## **Application by RWE Renewables UK Solar and Storage Limited for Peartree Hill Solar Farm (EN010157)**

### **The Examining Authority's (ExA's) second written questions and requests for information (ExQ2)**

**Issued on 24 September 2025**

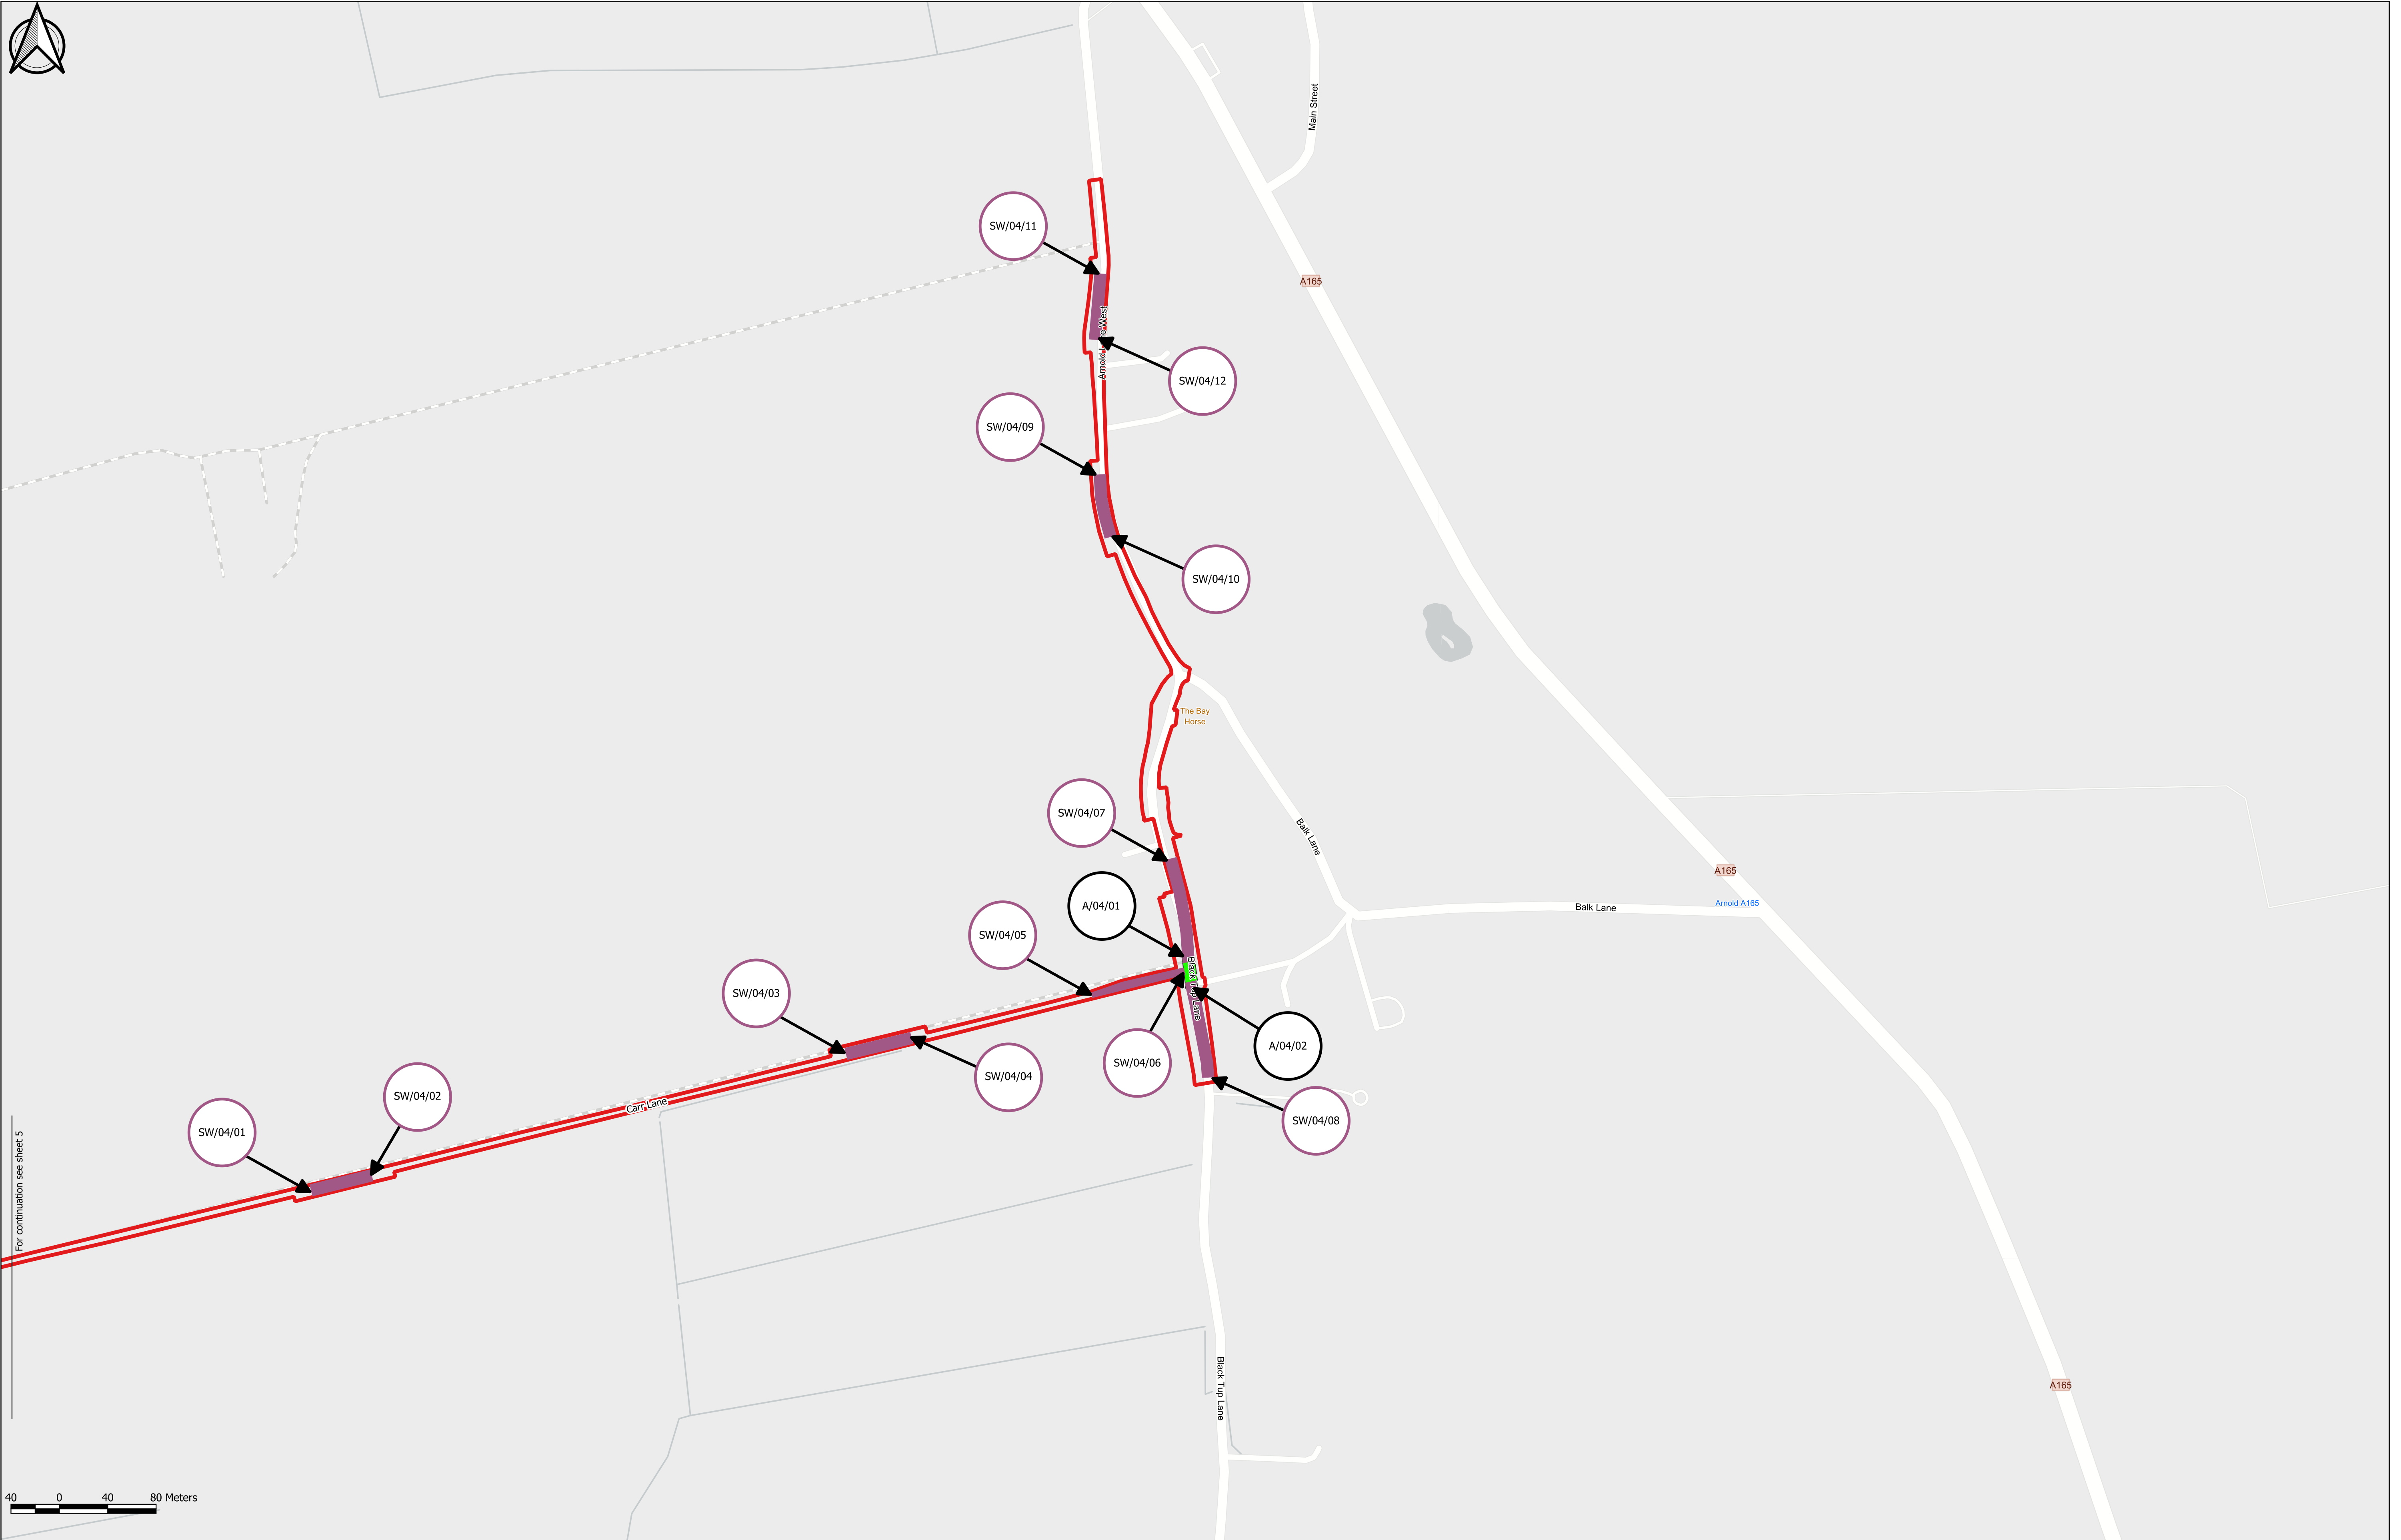
2.2.16	The applicant	Sch 4 – the entry for 'A1035' makes reference to 'SW/02a/01 to SW/02a/02' on sheet 2A of the Streets, Rights of Way and Access Plans. However, on this plan [REP2-051] the references are SW/2a/01 and SW/2a/02. Please ensure consistency between references on plans and within the dDCO.

2.2.18	The applicant	Sch 6 - the entry for 'A1035' makes reference to 'A/02a/01 and A/02a/02' on sheet 2A of the Streets, Rights of Way and Access Plans. However, on this plan [REP2-051] the references are A/2a/01 and A/2a/02. Please ensure consistency between references on plans and within the dDCO.
